Your Ref: SEP DEP DS and FRA Update
Date: 20 March 2023

My Ref: FW2023_0203
Tel No.: 0344 800 8020
Email: llfa@norfolk.gov.uk

Sheringham and Dudgeon Windfarm Extensions – Review of the updated Draft Flood Risk Assessment and Drainage Strategy

Figure 30: 1 in 100 Year Plus 20% for Climate Change with OnSS Platform Level Set at 28.23m AOD and North-West Access Road

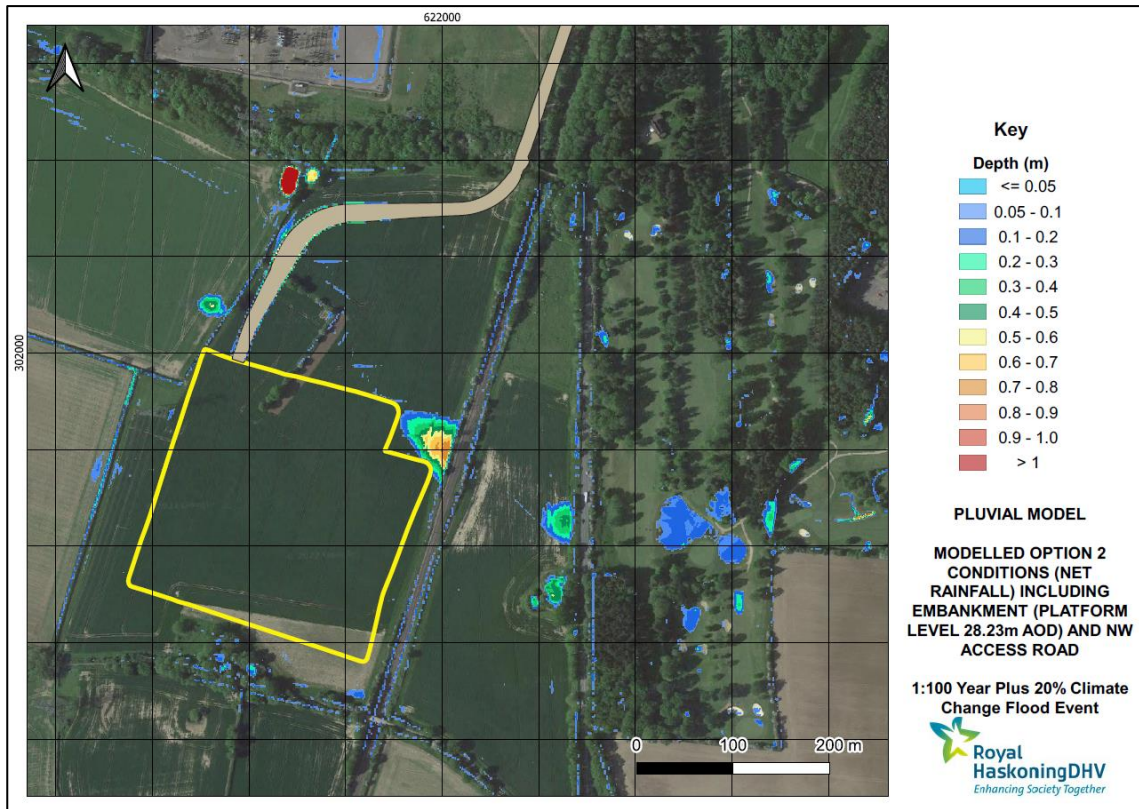
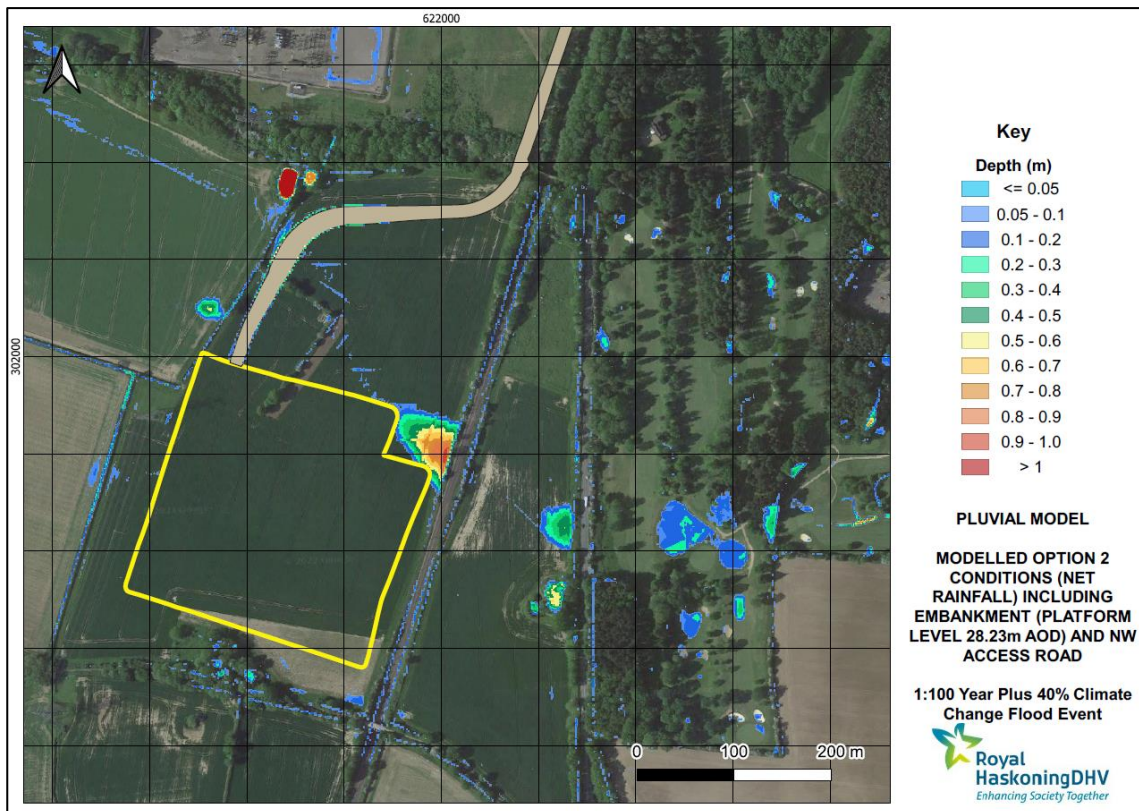
The LLFA notes that in section 106 of the report the applicant has provided an initial culvert size of 25m wide by 2.2m high. This is followed by a statement that the actual culvert size would be refined during the design process to ensure the conclusions of the modelling process remain valid. The LLFA requests confirmation of whether there is sufficient space to achieve the vertical alignment above the existing ground levels as no level information was observed in the report to determine whether the height was achievable within the access road vertical alignment and the existing topography.

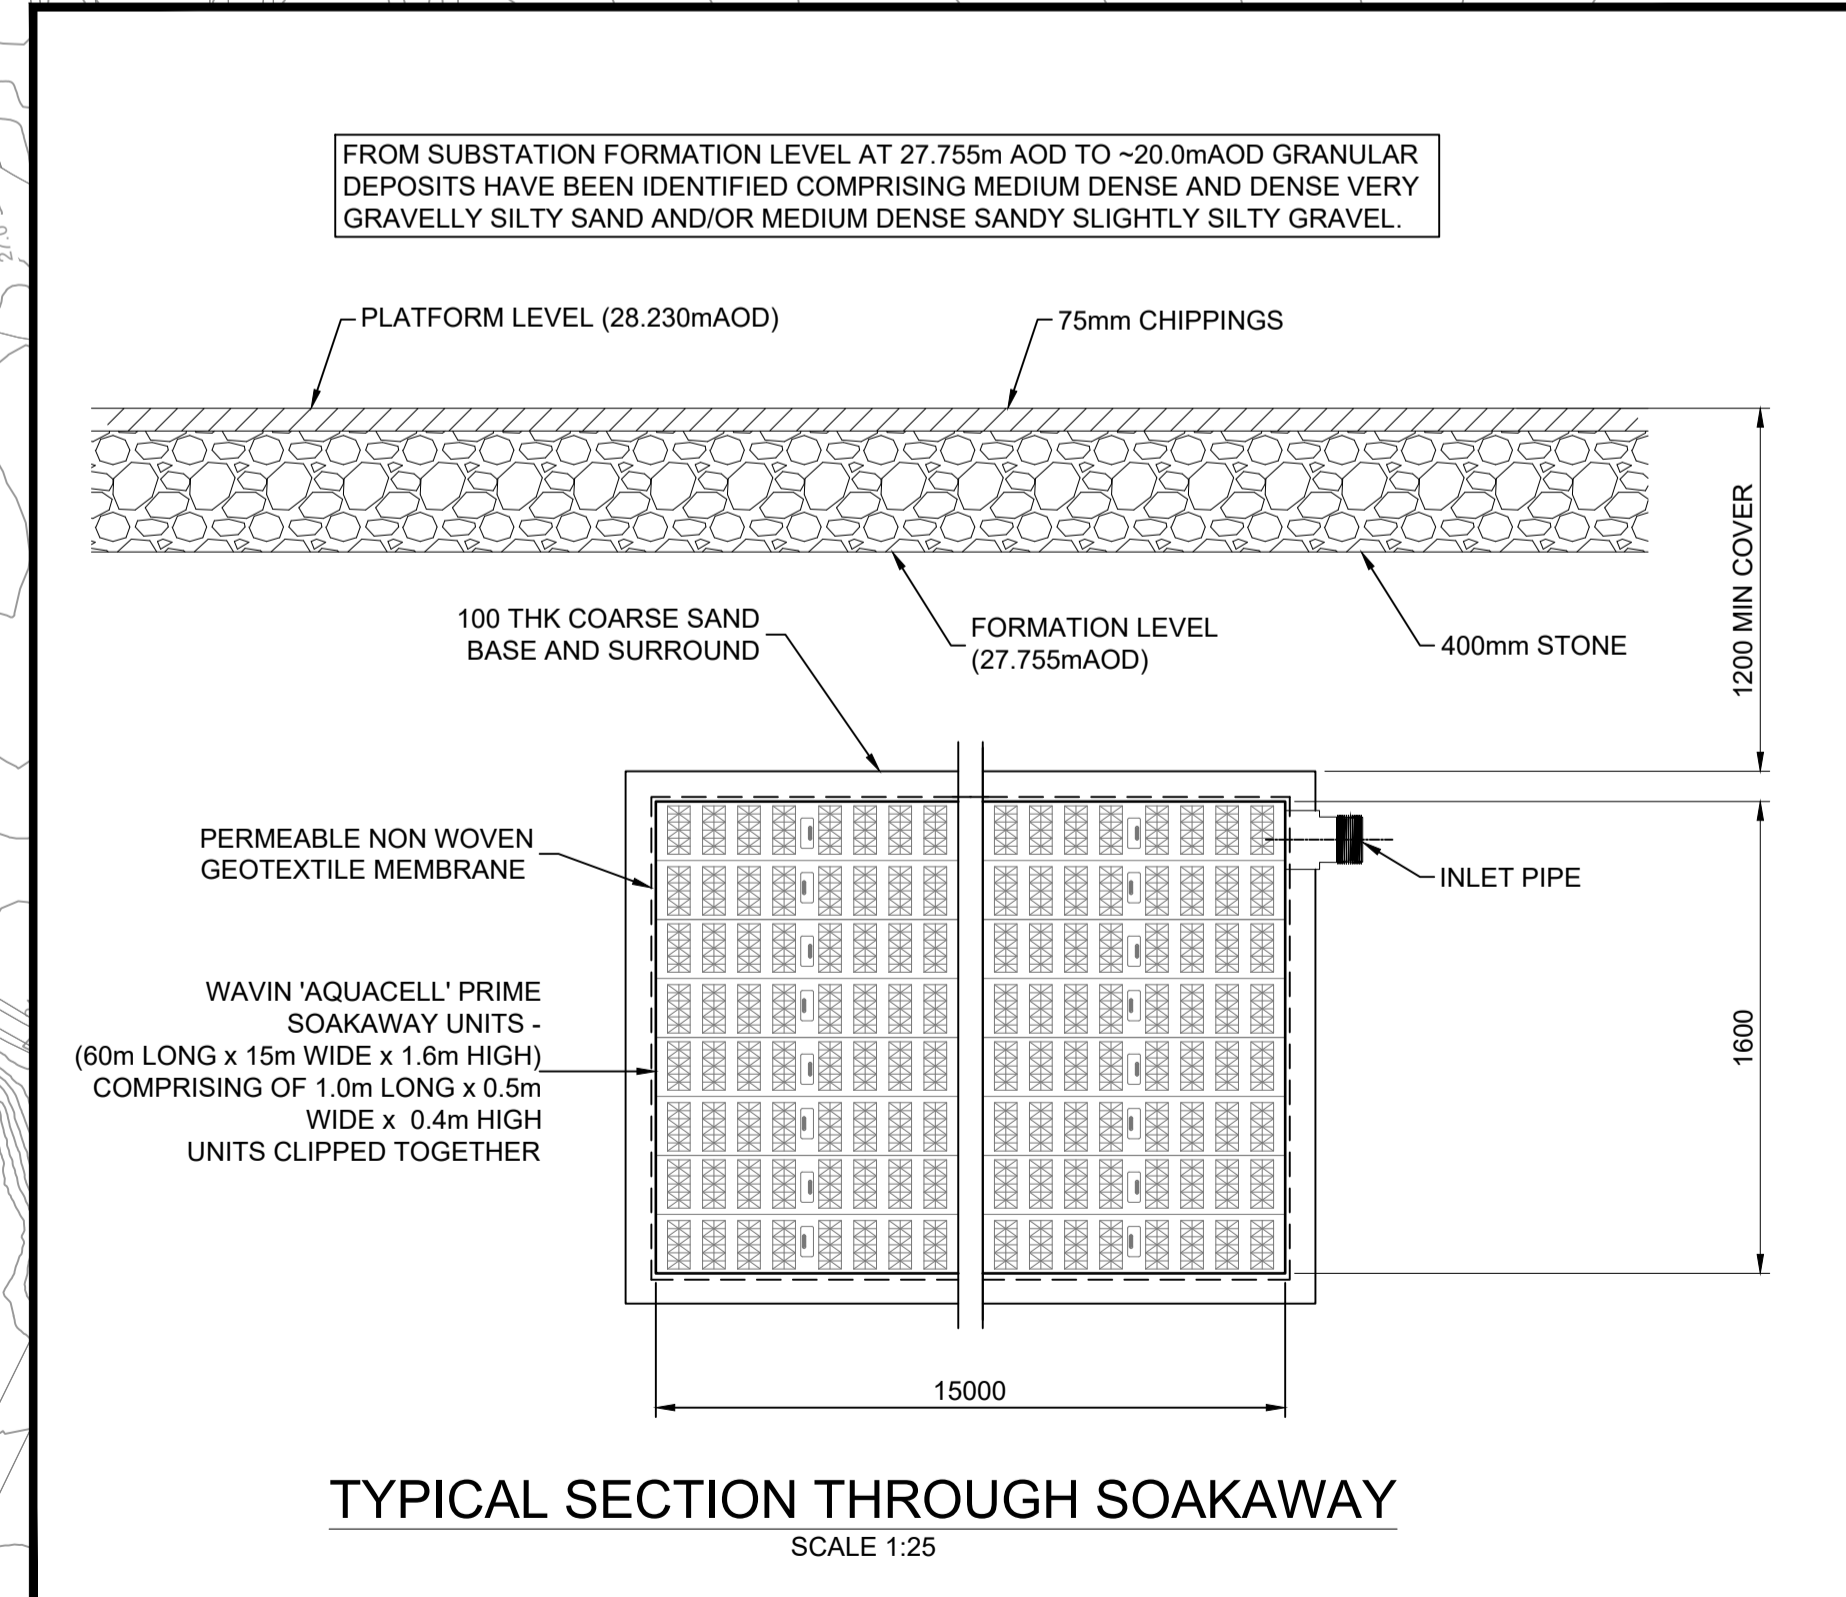
How likely is it that the full depth of the geocellular tank sides will be in use all the time? The BRE365 does state that the internal area of the soakaway is to 50% effective depth and excludes the base. At present it appears that the full depth of the storage tanks has been applied. Therefore, the LLFA consider this current approach inappropriate as the majority of the time the upper area of the tank is unlikely to have water against it to infiltrate. Therefore, the LLFA require that applicant update their surface water drainage calculations to reflect the 50% side area.

The LLFA notes the option 1 calculations for the 1% plus 45% for Climate change event are shown to flood in the 360, 480, 600, 720, 960 and 1440 storms. This indicates that at present the attenuation capacity is undersized and would lead to a volumed volume of between 32.5m³ to 165.7m³ leaving the system on the platform. Therefore, the LLFA would consider this an increase in flood risk.

A second set of untitled calculations where the full sides and the base area are used for infiltration are shown not to flood. In this scenario, a factor of safety of 2 is applied. As

there is a clear departure from the BRE365 guidance for this scenario, the factor of safety needs to be applied in accordance with the advice given in the SuDS Manual in chapter 25 and Table 25.2. As the area of the platform is clearly over 1000m² and the site would be considered critical infrastructure, the LLFA would expect at least a factor of safety of 10 to be applied unless it can be shown there is suitable mitigation in place to lower the impact of flooding to the infrastructure onsite. At which point the LLFA would accept a factor of safety of 5.
